173-179 Walker Street and 11-17 Hampden Street, North Sydney SSD-67175465 | Public Exhibition Submission | Objection

This letter has been prepared by CASA, the owners of 45 McLaren Street, North Sydney with regards to the proposed residential development at 173-179 Walker Street and 11-17 Hampden Street, North Sydney (**the site**), which is currently on public exhibition until 21 November 2024.

This letter provides a formal objection to the State Significant Development Application (SSDA), referred to as SSD-67175465. We note that the SSDA was previously placed on public exhibition from 5 July 2024 – 1 August 2024 and the current exhibition package forms an amendment to the original submission.

**Figure 2** Amended building footprints and Setbacks for the Amended Development

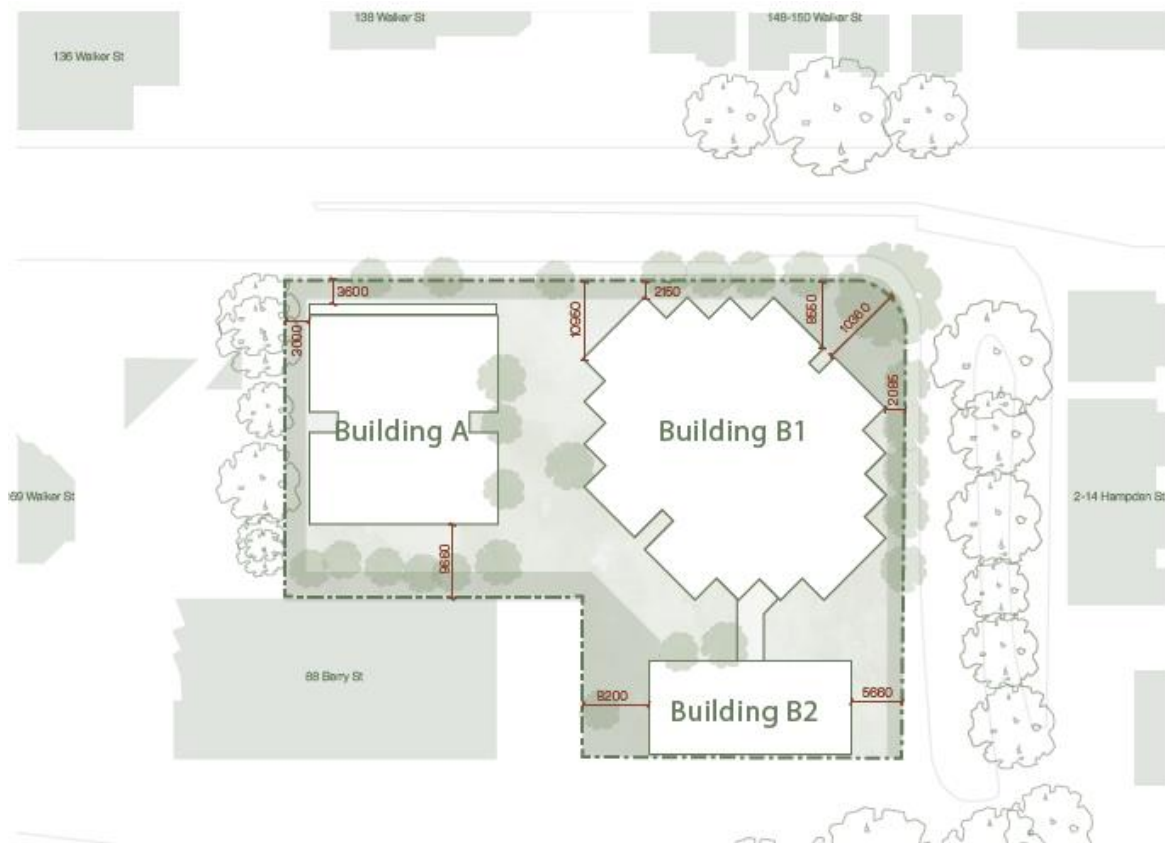
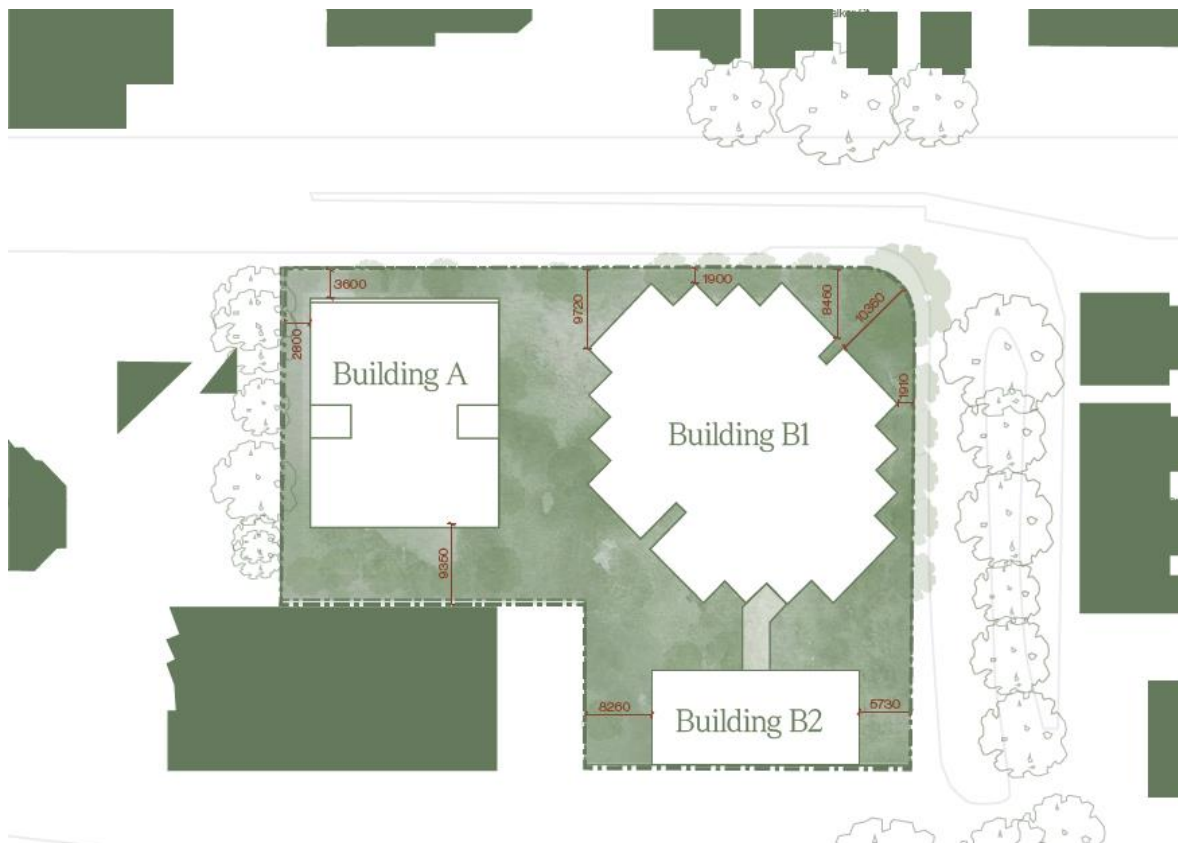
The amended architectural plans which have been placed on exhibition have done little to reduce the width of the main tower envelope which has increased by 8m in width and has therefore had a far greater impact on the ability to equitable promote view sharing across the site.

Objection: In order to ‘strike a balance’ between facilitating new developments, while preserving access to views, the width of the tower envelope should be reduced to provide a slender tower form that promotes view sharing across the site.

When drawing comparisons between the two schemes, it appears that the tower envelope that formed part of the Planning Proposal had a width of 30m (from north to south), comparative to the proposed tower width of approximately 38m. The enlarged tower floor plate directly correlates with the loss of views and does not uphold the same level of equitable view sharing that has been accepted on the site.
